A47 Blofield to North Burlingham Dualling

Scheme Number: TR010040

Volume 9 **9.24 Request for a Non-Material Change to the Application**

REQUEST FOR A NON-MATERIAL CHANGE TO THE APPLICATION

Drawing Number	Rev
Highways England PIN	
HE551492-	P05
GTY-LLO-000-DR-BL-00005	
Location

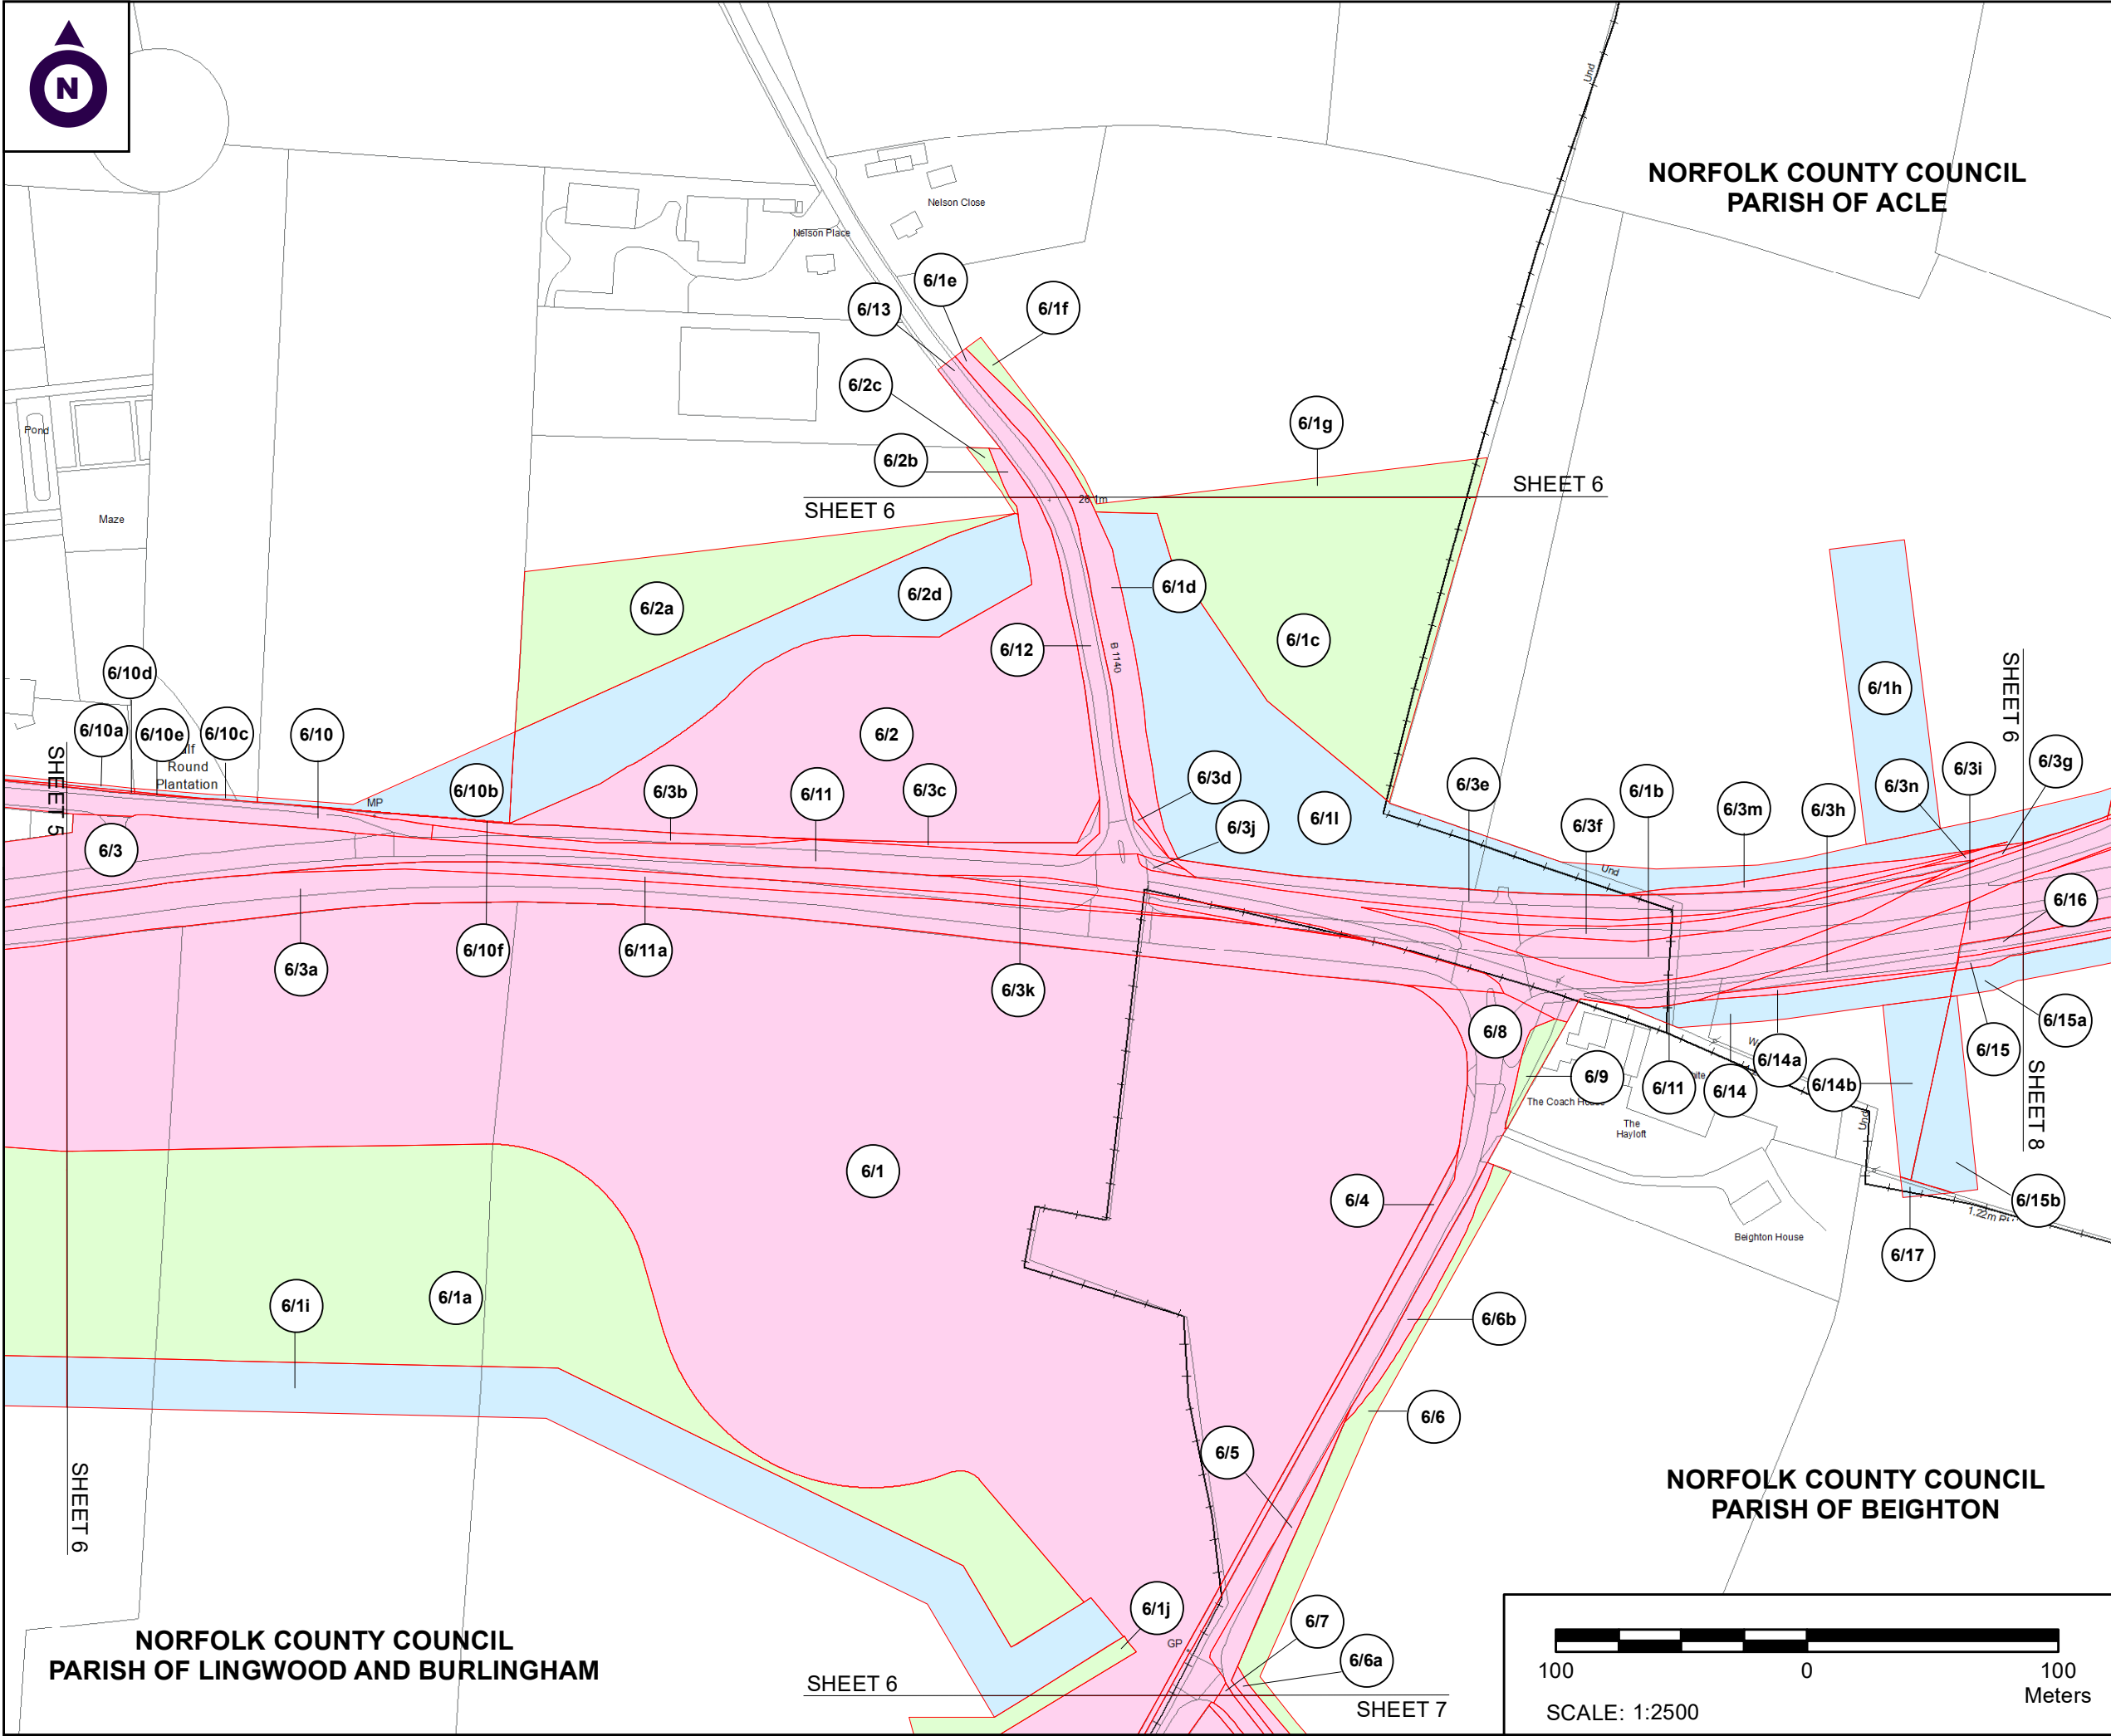
- 2.1.4 The Existing Block Valve Site is shown on sheet 5 of the Land Plans as plot 5/2 (**REP4-002**).
- 2.1.5 The Existing Block Valve Site comprises a block valve site, which is a fenced-off, above-ground facility situated where an existing gas main on a north-south alignment (the North-South Gas Main) crosses a second existing gas main on an east-west alignment (the Existing East-West Gas Main) which is to be diverted to a new route (the Diverted Gas Main) (see Work No.5, Schedule 1 to the dDCO (**REP5-002**)).

- 2.1.7 To allow the provision of the New Block Valve Site, a new permanent acquisition plot (plot 5/1e) has been added to the Land Plans (**REP4-002**) and the Book of Reference (**TR010040/APP/4.3 Rev 6**) (submitted at Deadline 6) on land for which temporary possession was previously sought. It is anticipated that this land would be vested in Cadent after completion of works. The extent of this plot reflects the limits of deviation for Work No.5, and a degree of uncertainty as to the precise location of the North-South Gas Main (historical records as to the location of the apparatus of statutory undertakers is generally imprecise).

- 2.1.8 In addition to acquiring the New Block Valve Site, it will be necessary to provide a replacement access to the New Block Valve Site (Replacement Access). The Existing Block Valve Site is accessed directly from the existing A47, however this will not be possible for the New Block Valve Site. It is therefore proposed to provide a new access track, leading south from the access track included in Work No. 23. New rights will be required for the new access track between Work No.23 and the Diverted Gas Main, and this has necessitated the creation of a new rights plot (plot 5/1b). Although the description of Work No.5 does not need to change, the limits of deviation for Work No.5, shown on sheet 5 of the Works Plans (**REP4-003**) need to be amended to take into account the land on which the Replacement Access is to be provided.

- 2.1.9 Finally, the new access track will need to provide sufficient room for van and trailer to turn around. As a result it is necessary for the access track to continue over the line of Work No.5 as far as the Order Limits. This land will remain "blue" land (limited to the acquisition of rights and for temporary possession), however in addition to the rights to install and keep the Diverted Gas Main in the land, access rights will also be required over the land. As a result a new rights plot (plot 5/1g) has been added to the Book of Reference (**TR010040/APP/4.3 Rev 6**) (submitted at Deadline 6) and the Land Plans (**REP4-002**).
